**KIRKLEES METROPOLITAN COUNCIL
INVESTMENT & REGENERATION SERVICE**

DELEGATED DECISION TO DETERMINE PLANNING APPLICATIONS

Reference No:	2026/62/91532/W
Site Address:	4-6, Cambridge Road, Huddersfield, HD1 5BU
Description:	Change of Use from Bridge Club to Guest House and associated alterations
Recommending Officer:	Elenya Jackson

DECISION - REFUSE

#### Proposed Attic Floor

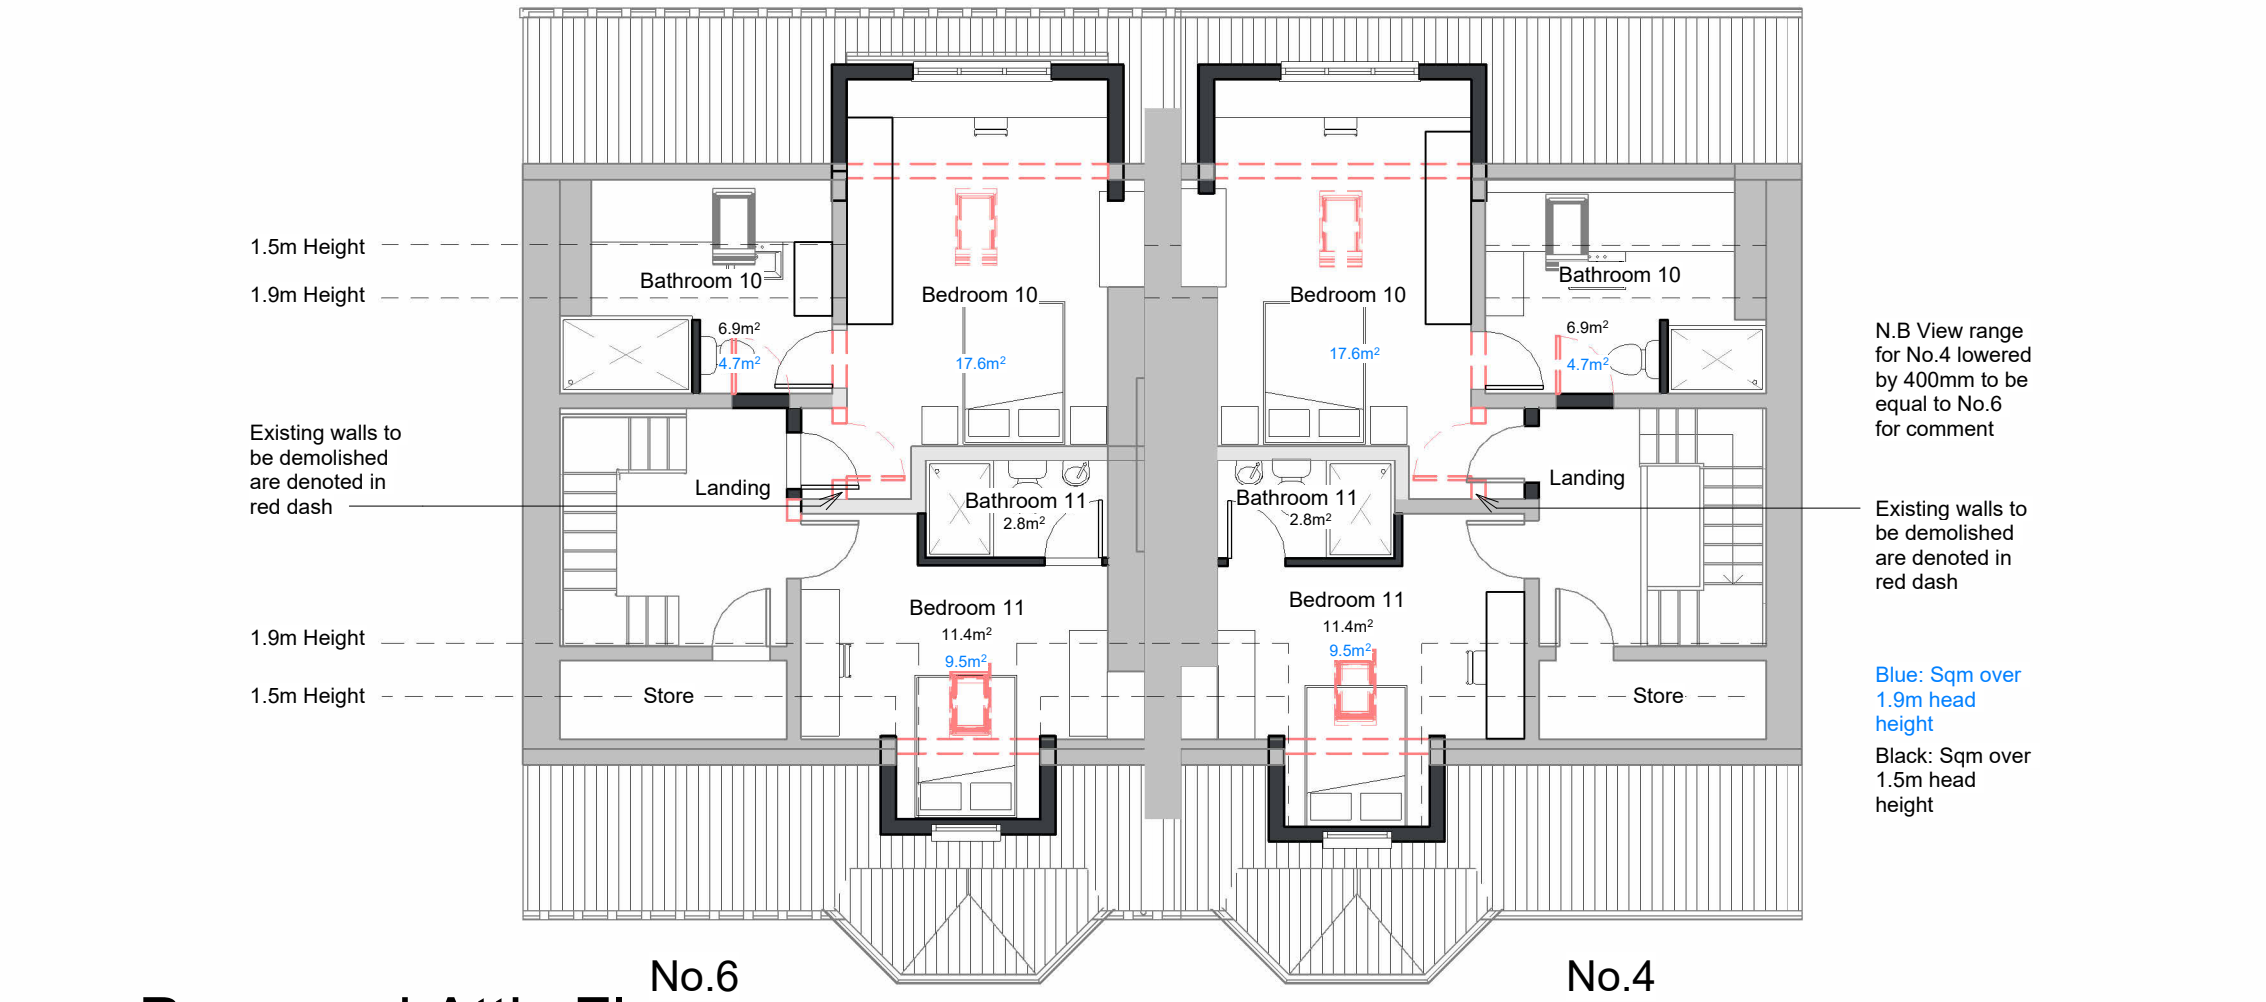
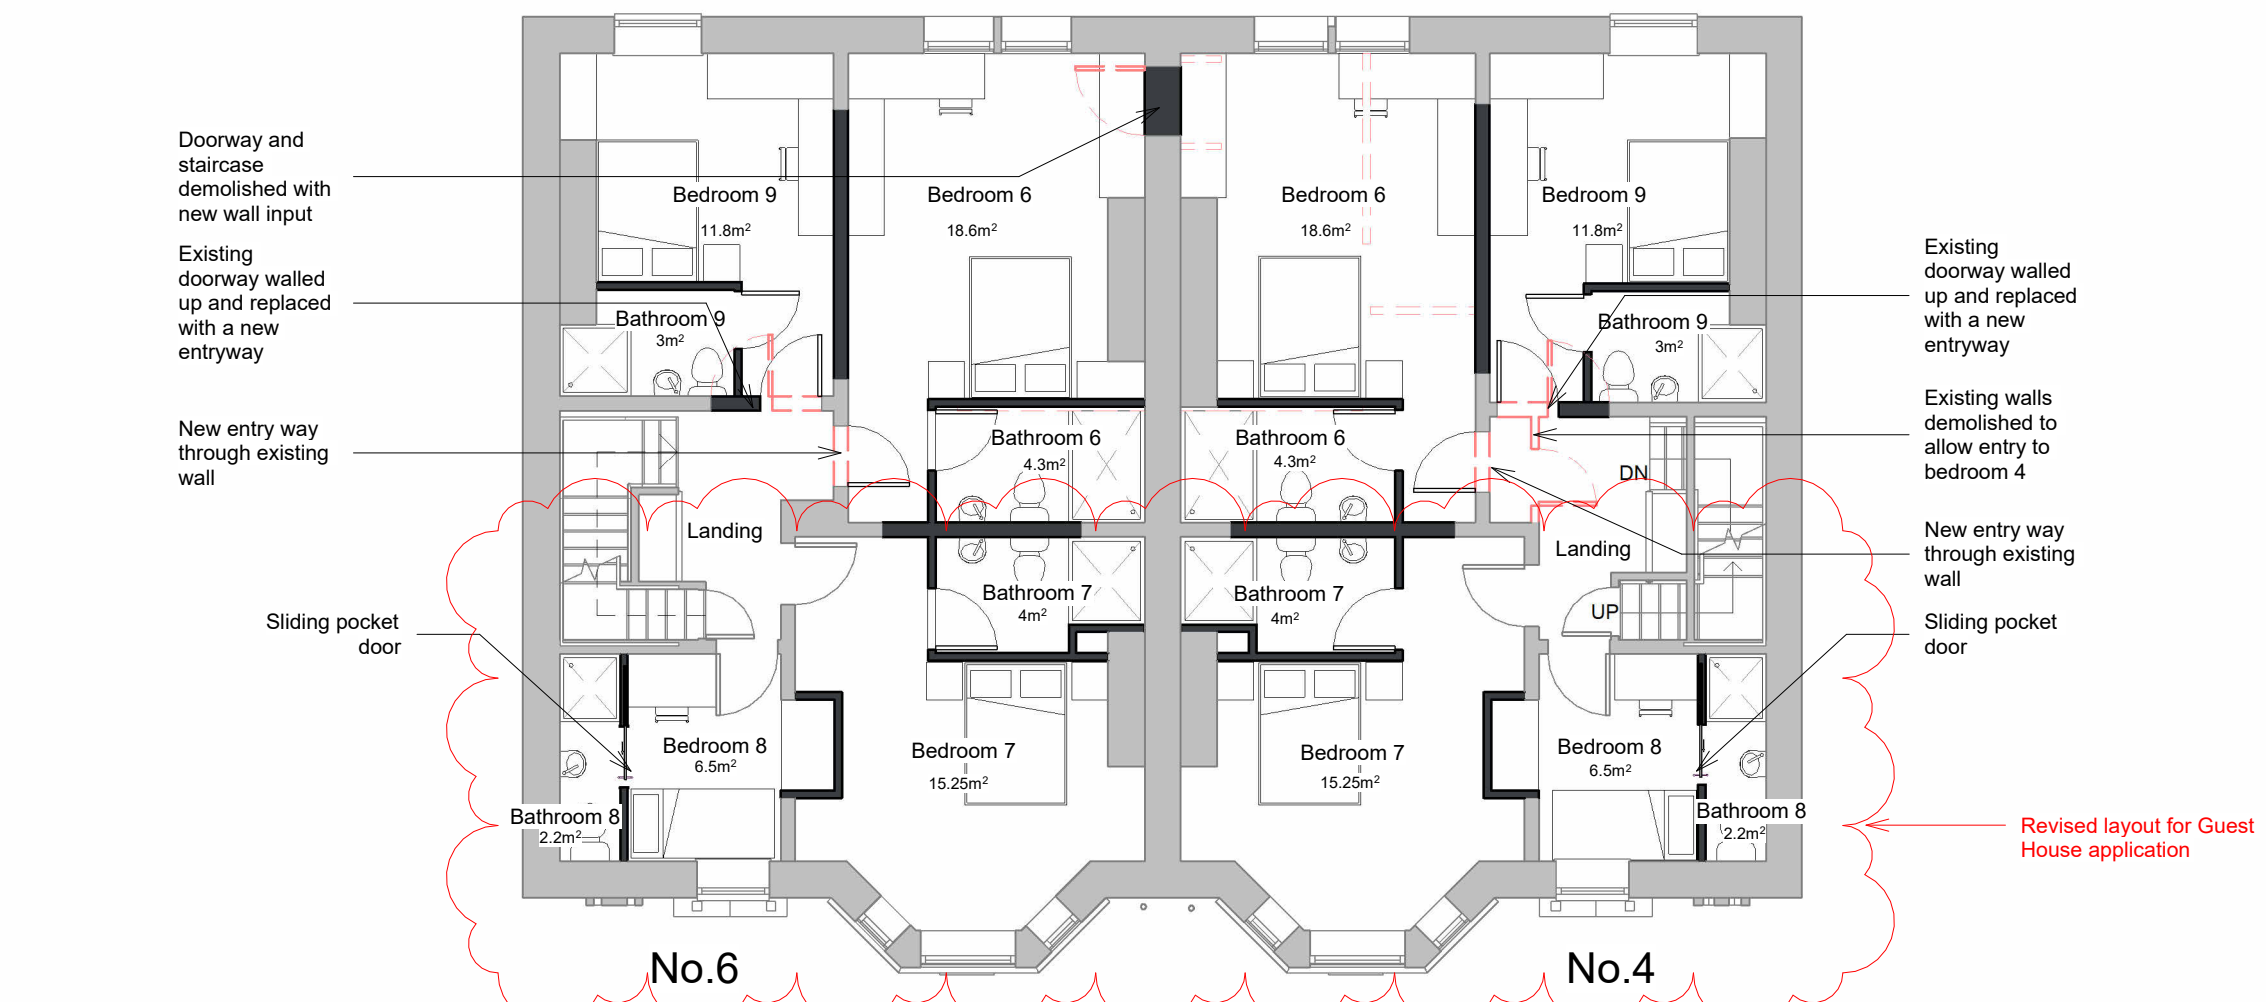
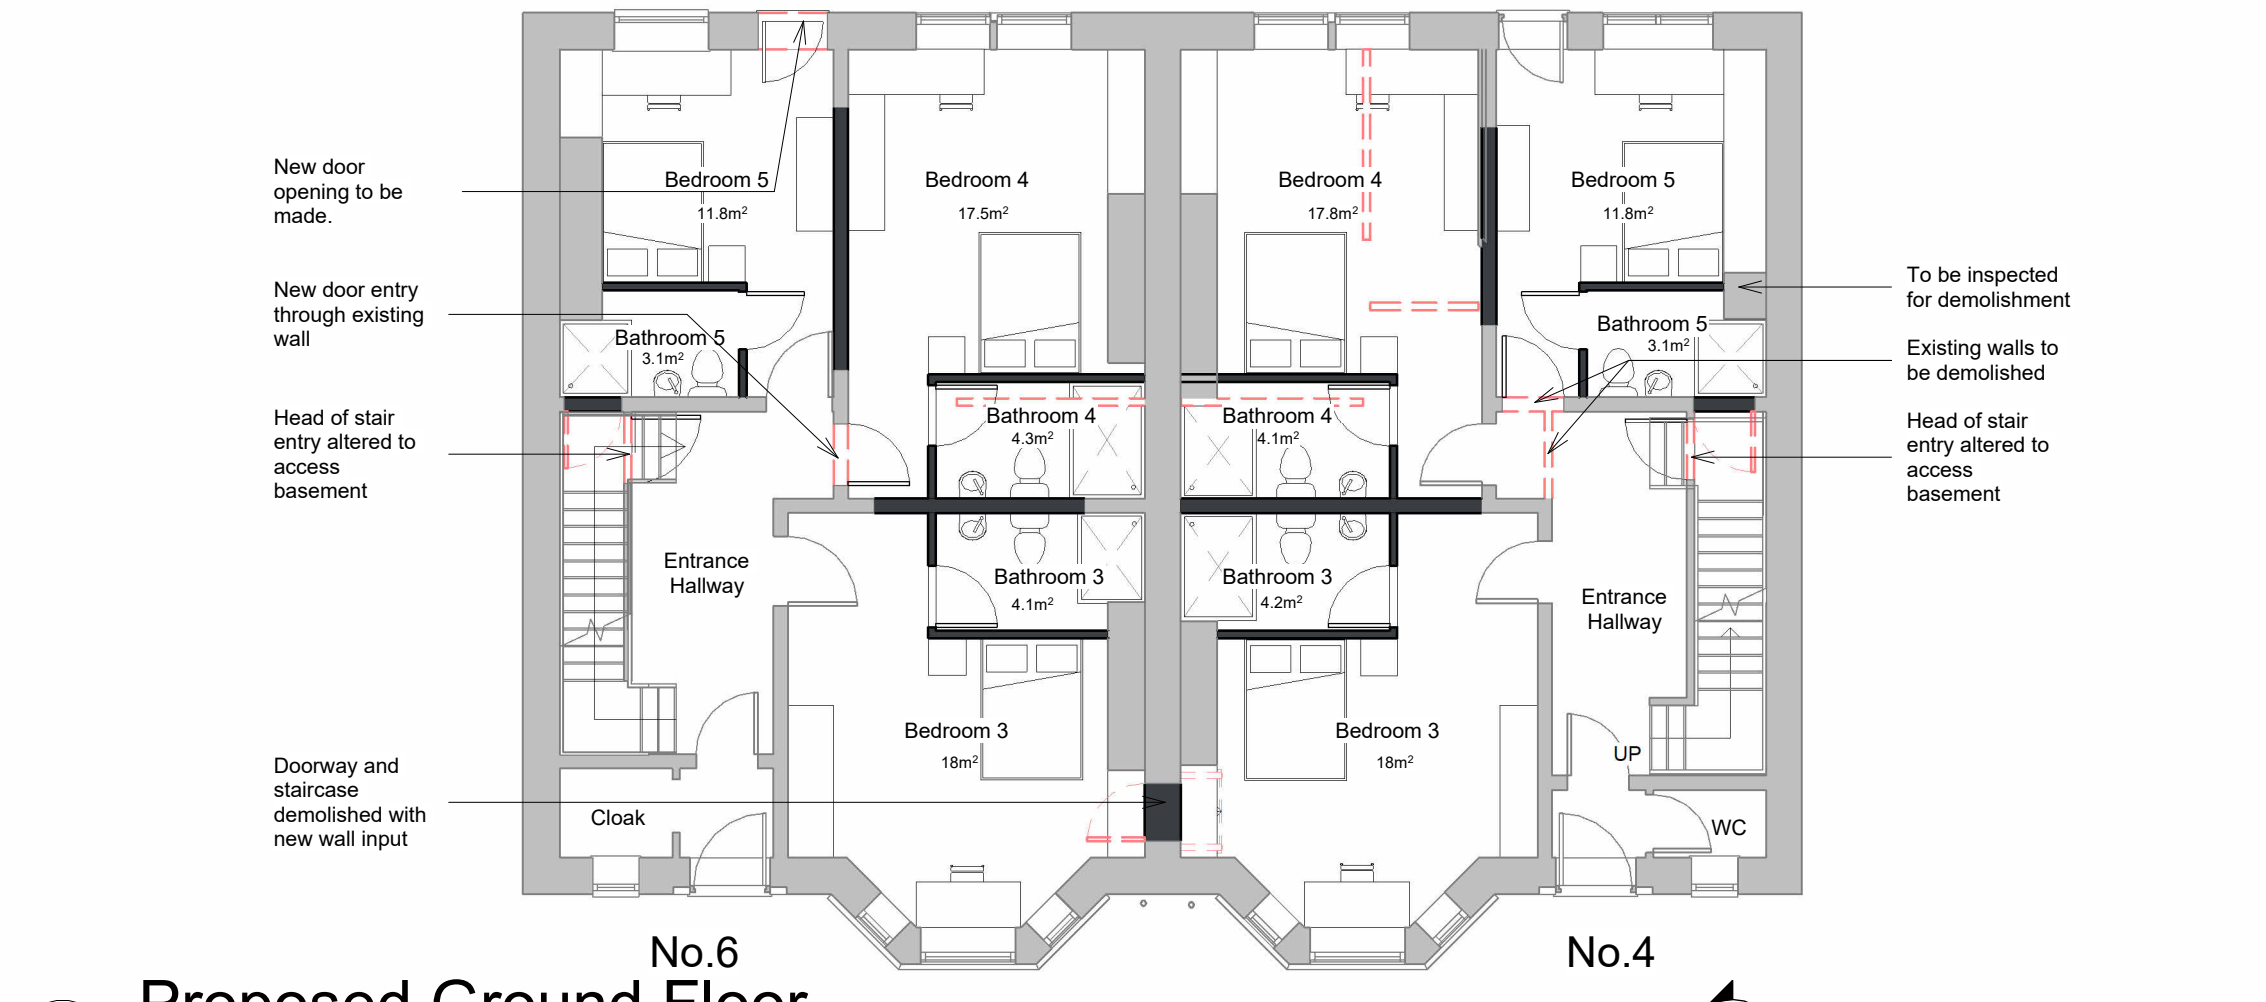
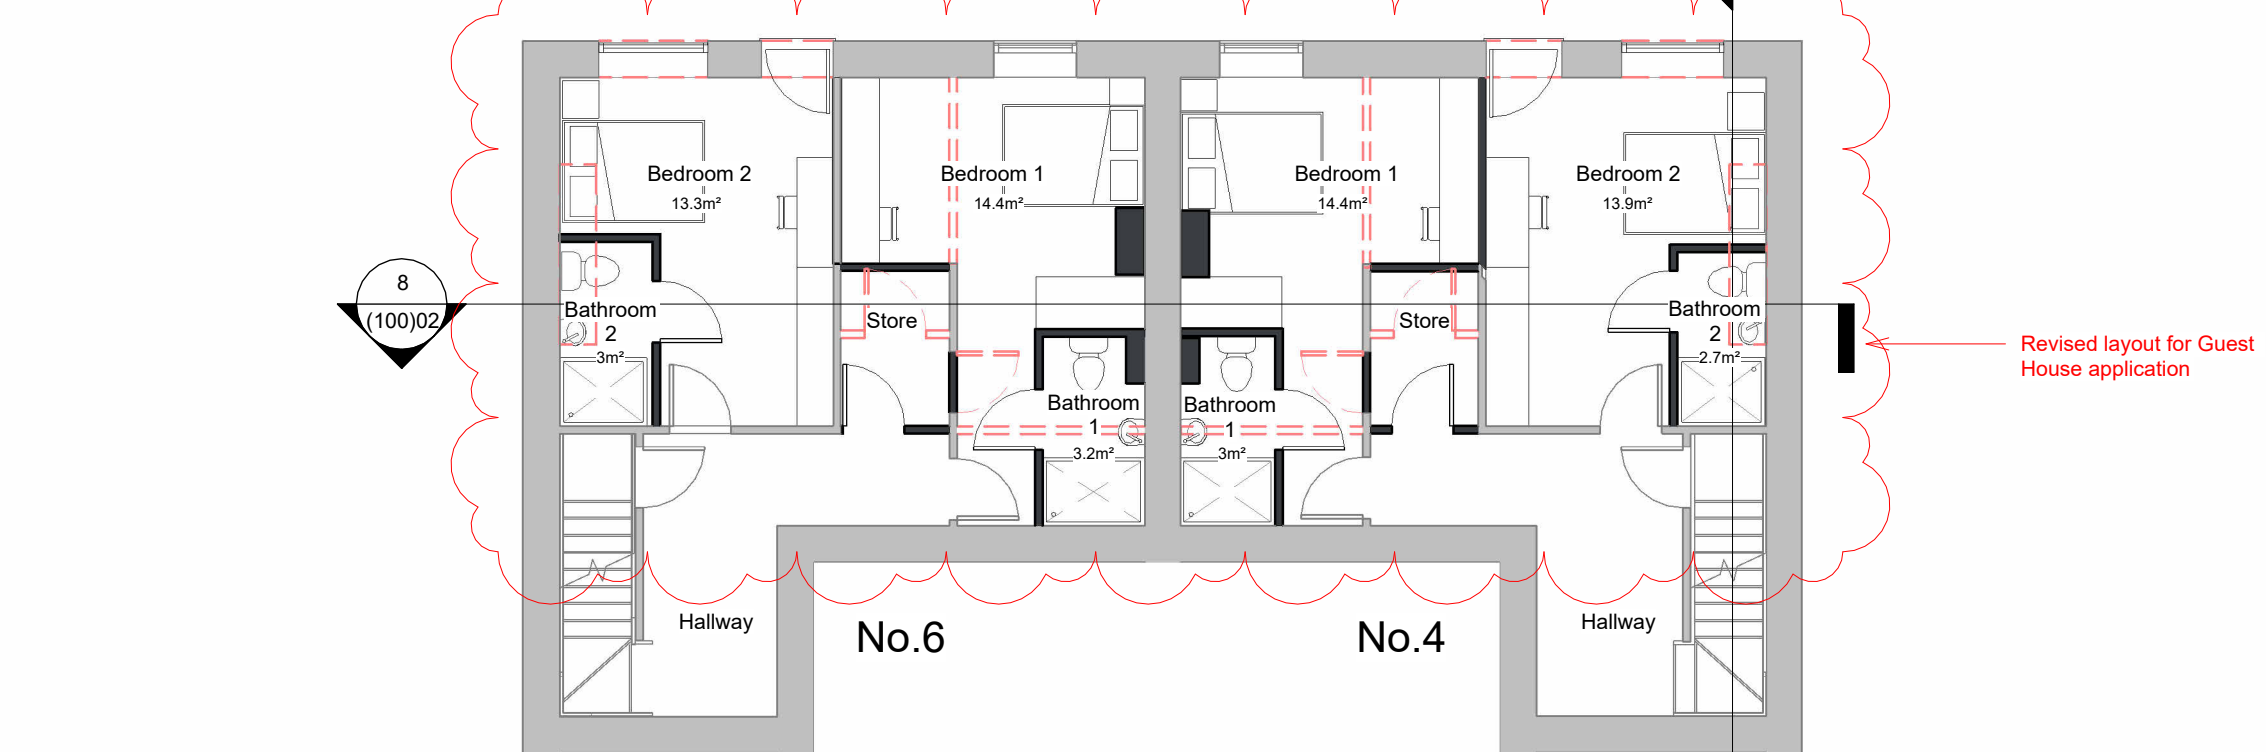
The proposed floor plans show all the proposed accommodation would fall substantially short of space standards. However, officers consider that, the proposal would not operate as an independent dwelling and would be a short stay guest house; therefore, the proposal would not be required to accord with space standards.

#### Proposed Front Elevation

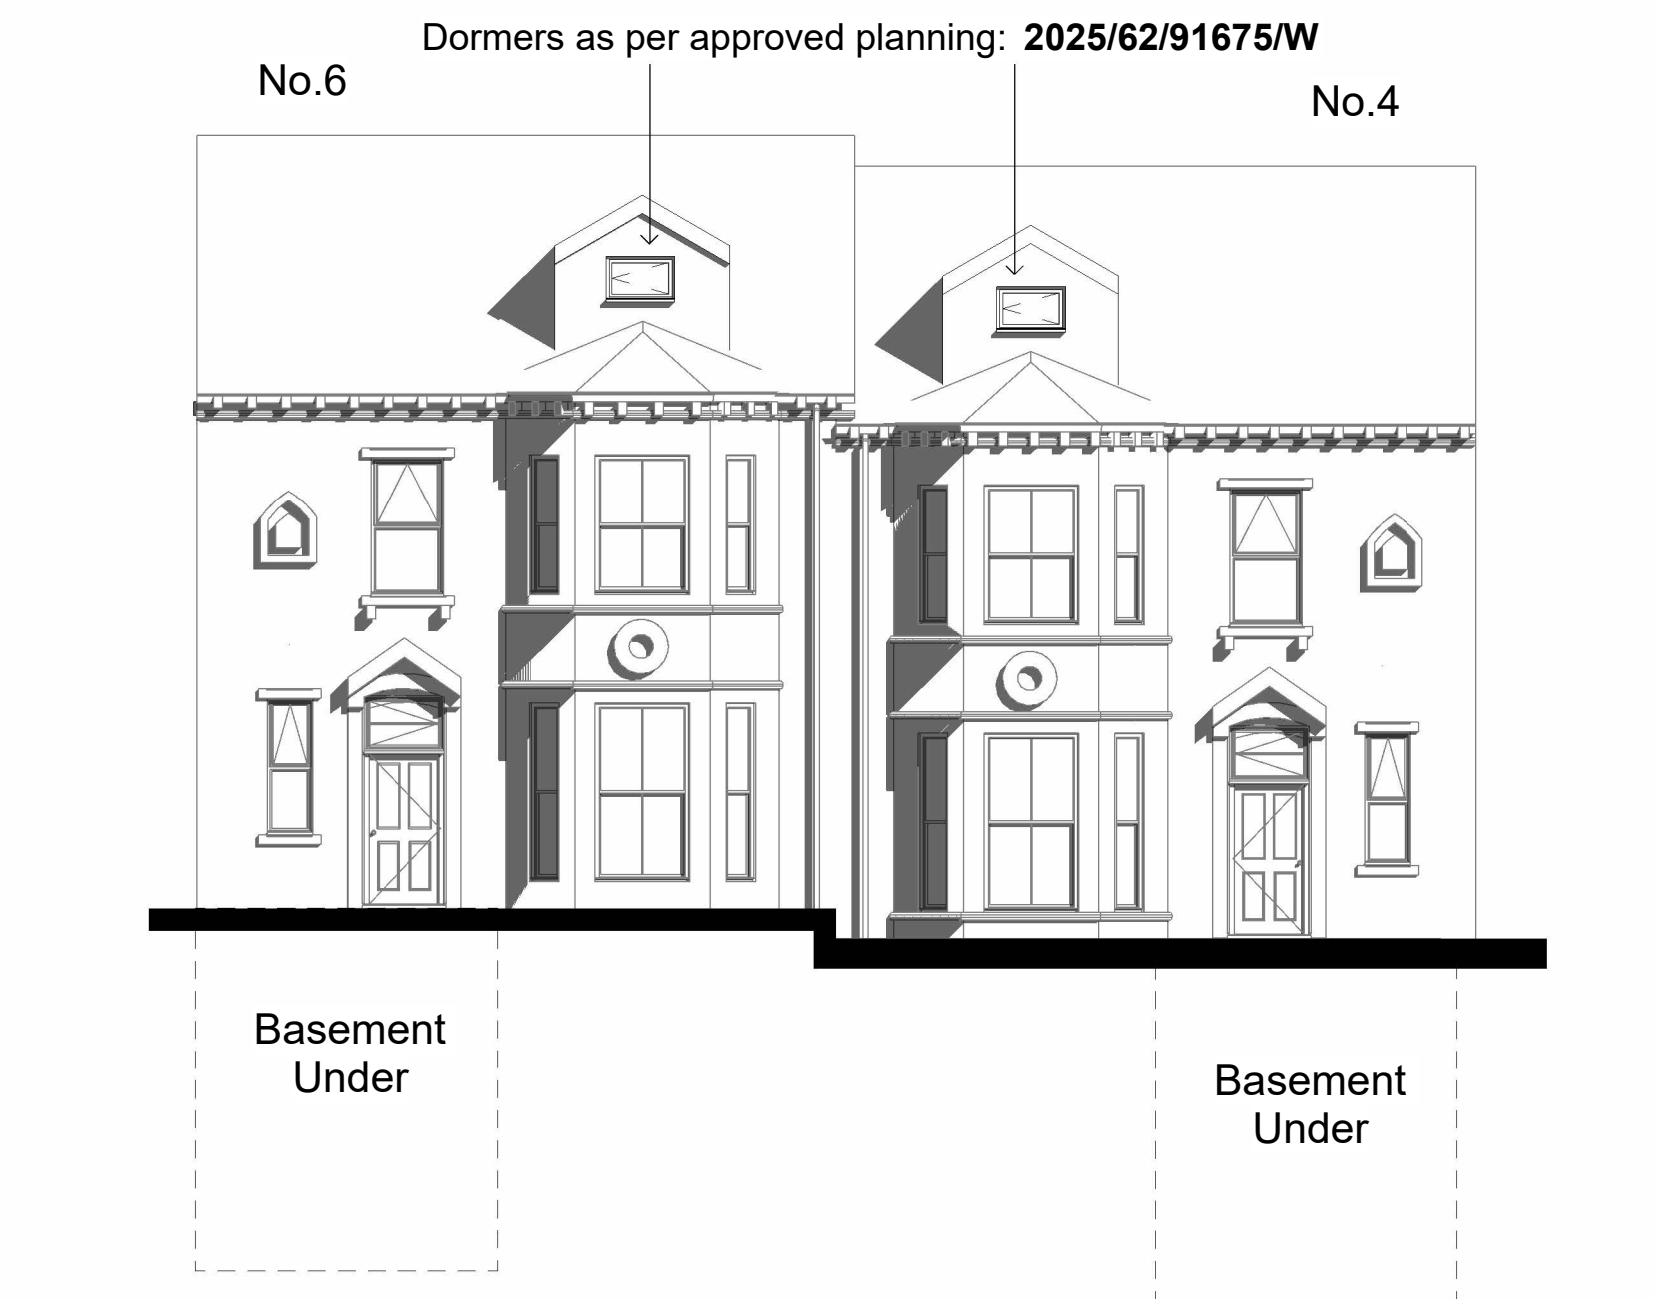
Officers consider that the dormers have previously been established under the previous applications on site and although the dormers are located on the front elevation of the properties, this is characteristic immediate building group and therefore the addition of dormers to the dwelling would not be inappropriate.

Officers consider that the front dormers would face into the street scene and not raise any concerns regarding residential amenity as this is considered a usual relationship.
